Application for a non-material amendment following a grant of planning permission.

SINGLE STOREY EXTENSION TO PROVIDE GARAGE

H21 - 0310 - N

REMOVAL OF GARAGE ATTACHMENT TO EXISTING DWELLING
PROPOSED DOUBLE GARAGE TO BE DETACHED

DRG NO. 1036/02A

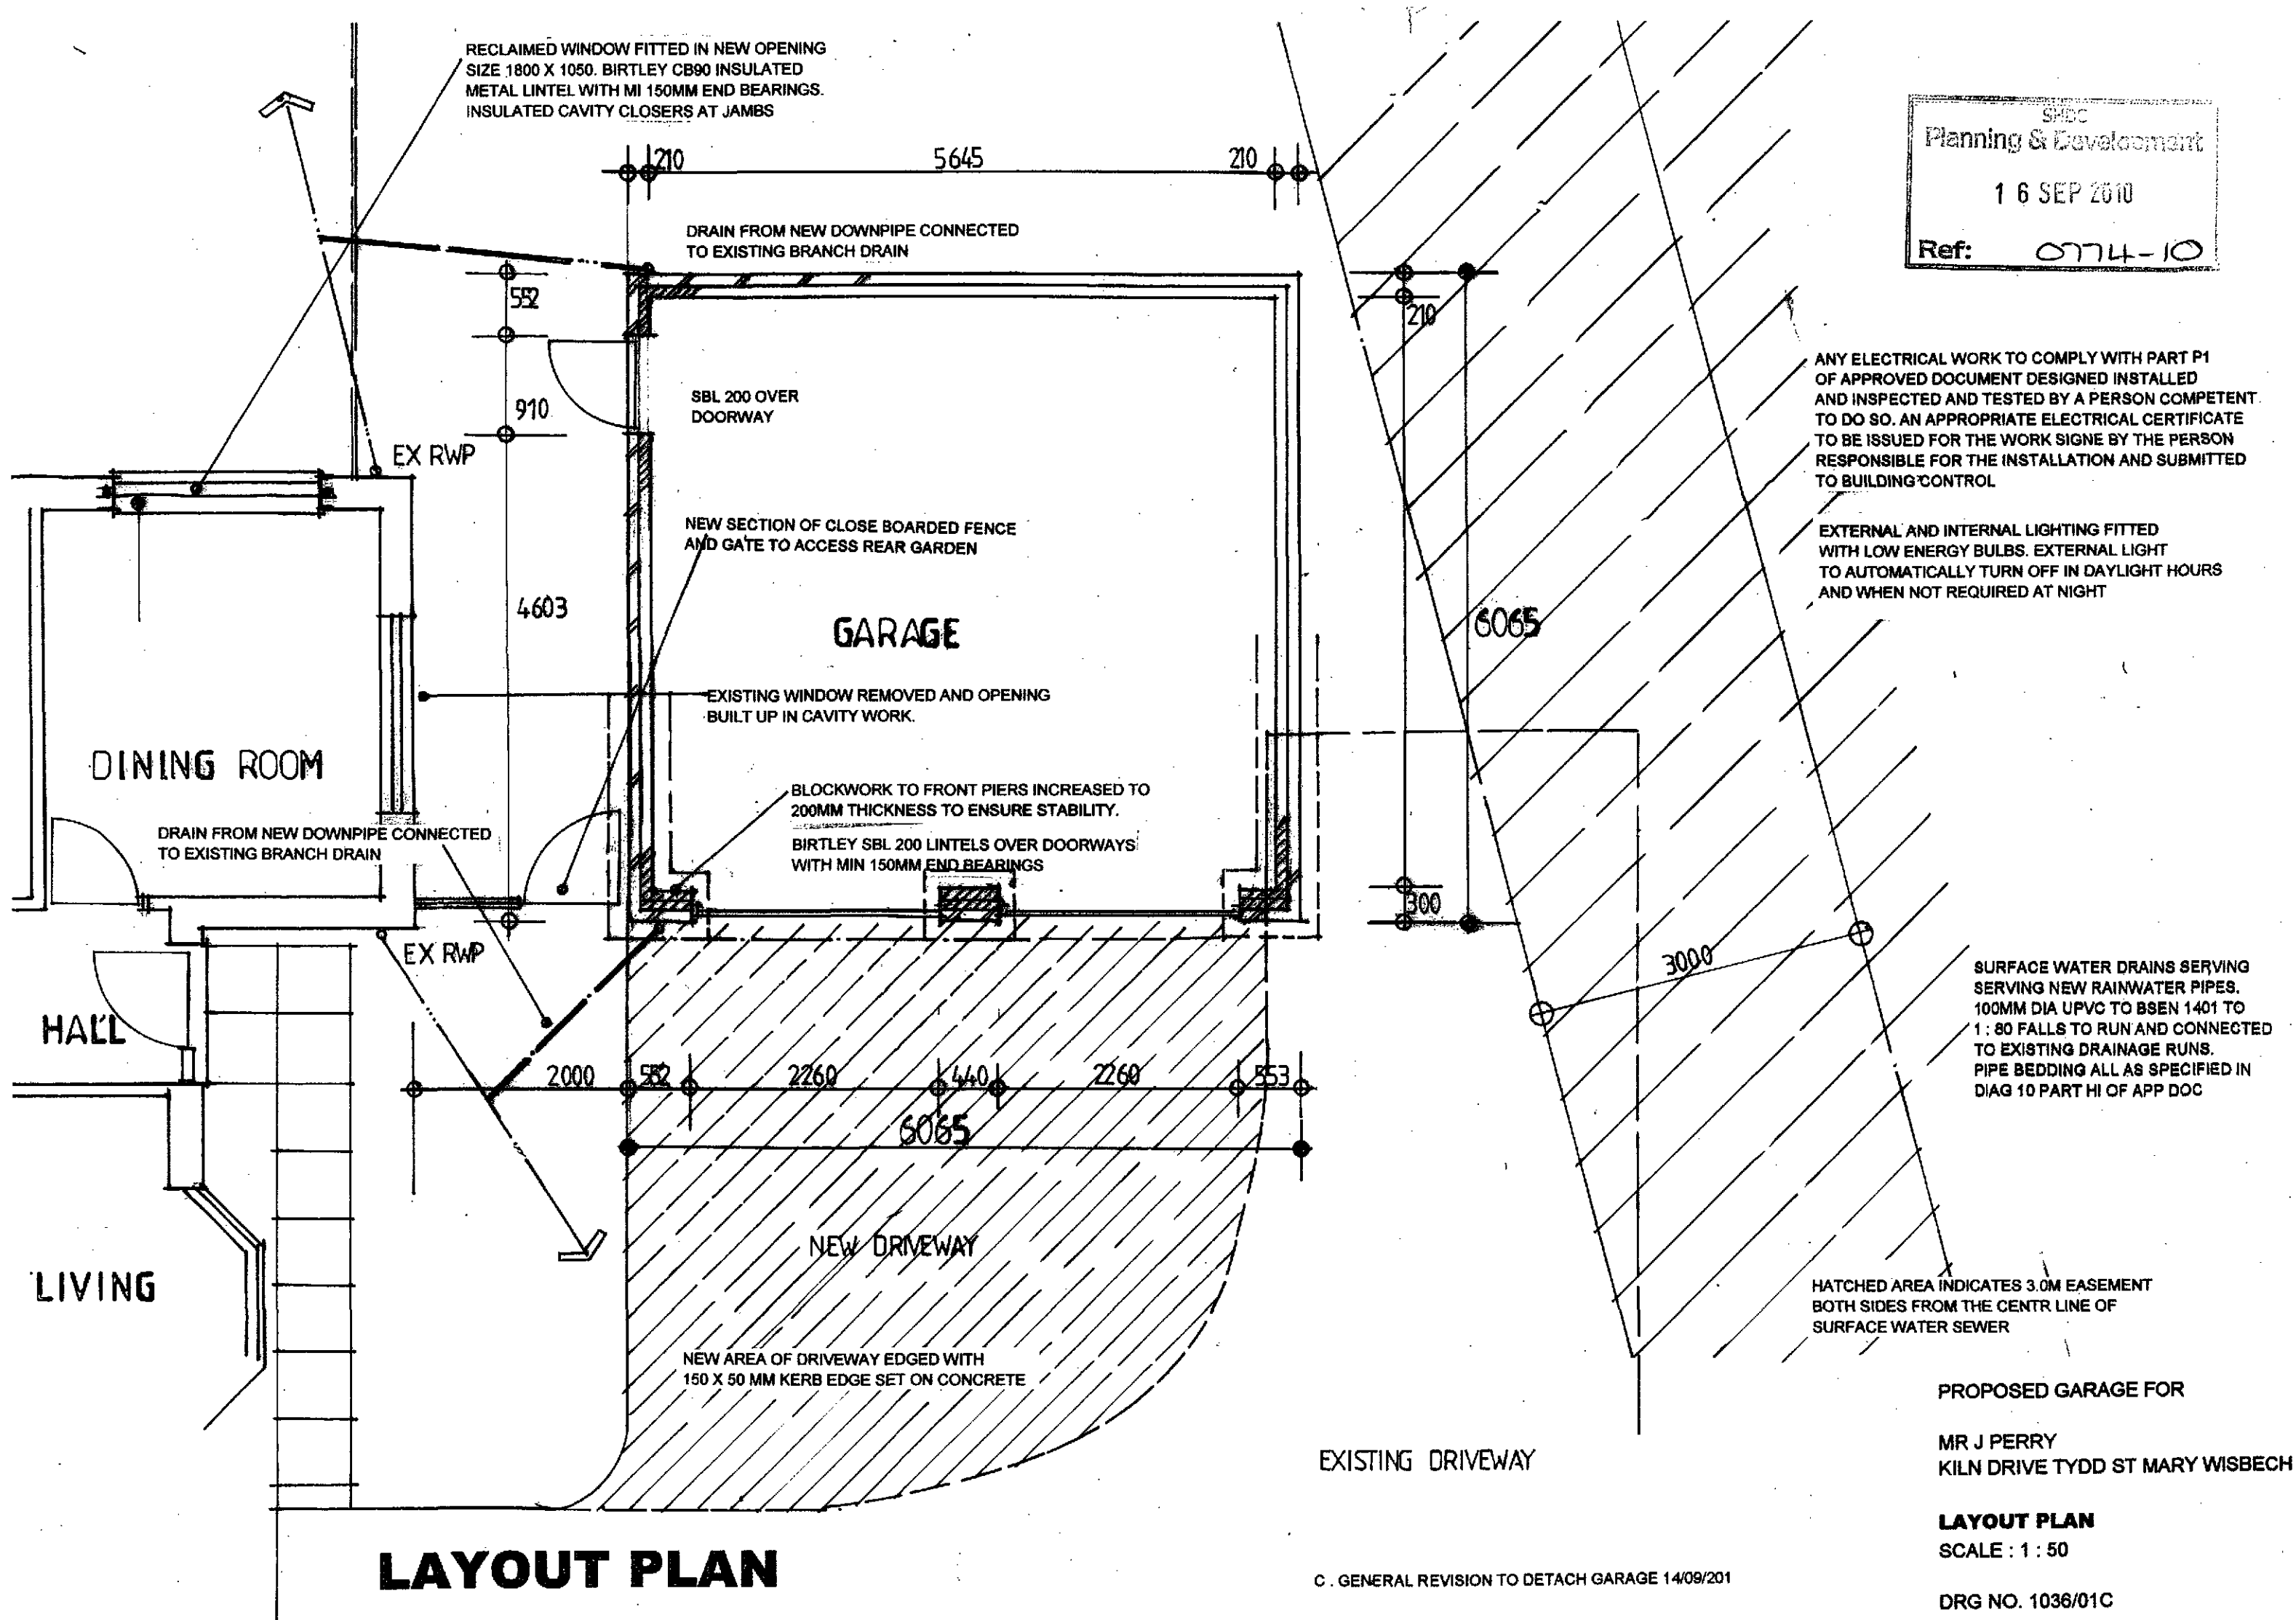
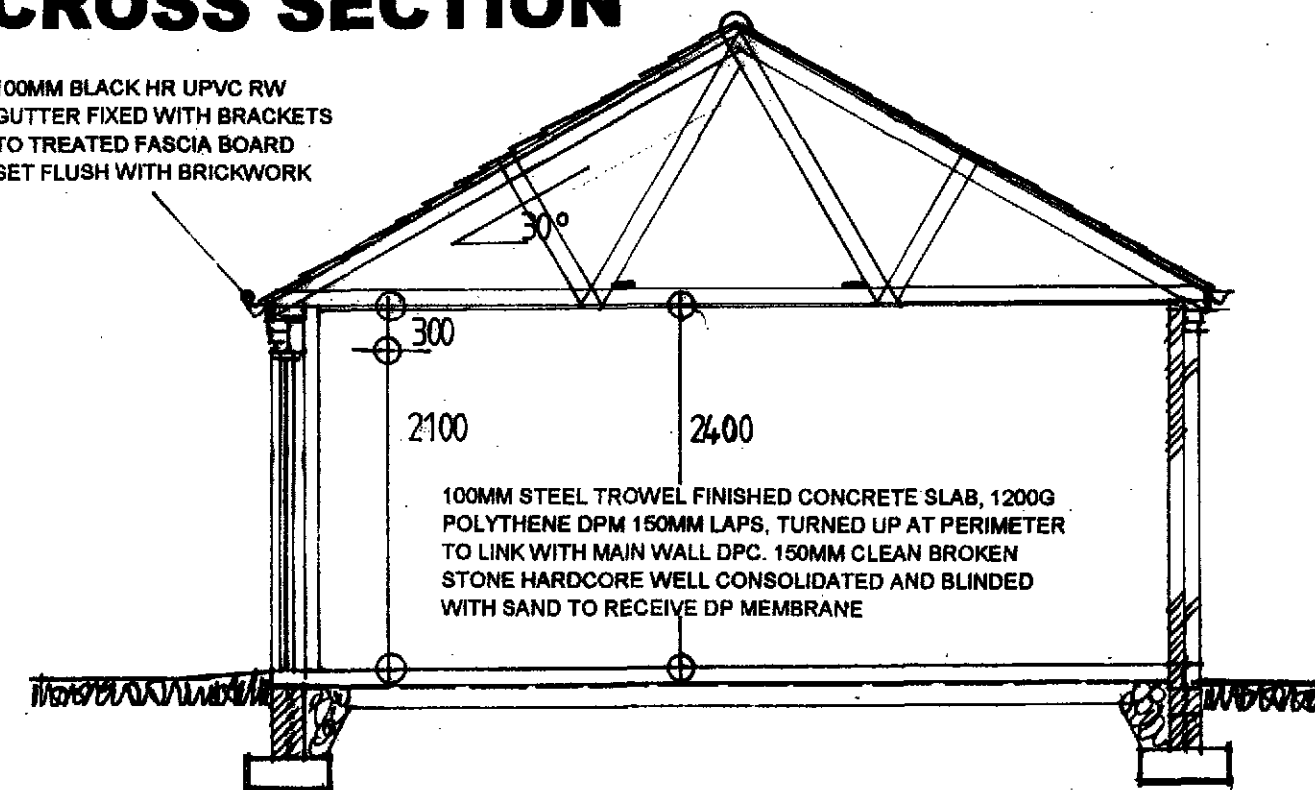
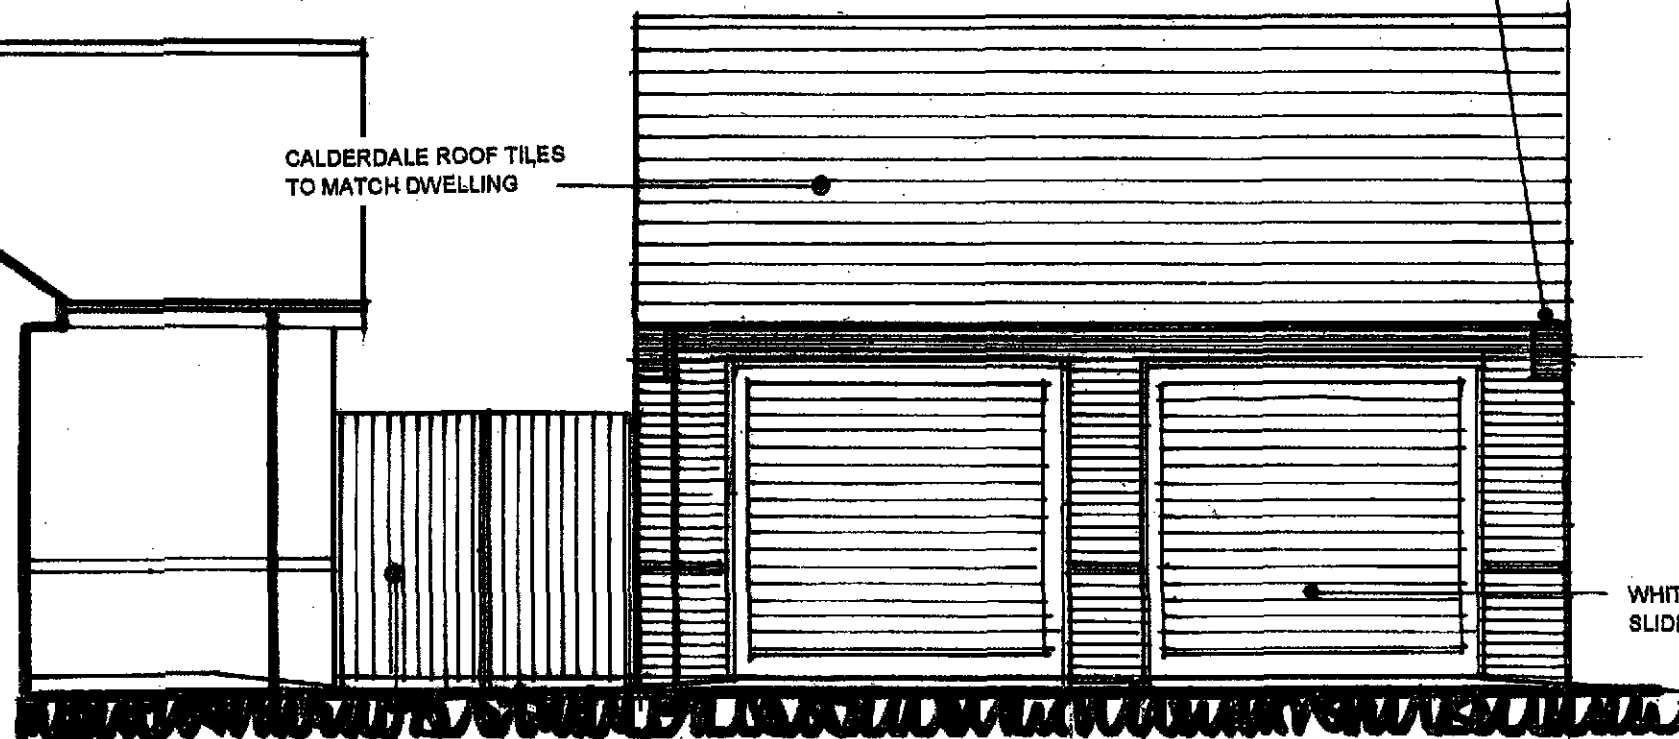
GROUNDWORKS TO APPROVED EXTENSION WOULD CONFLICT
WITH PILED FOUNDATIONS SUPPORTING EXISTING DWELLING
CAUSING EXTENSIVE AND DIFFICULT UNDERPINNING WORK
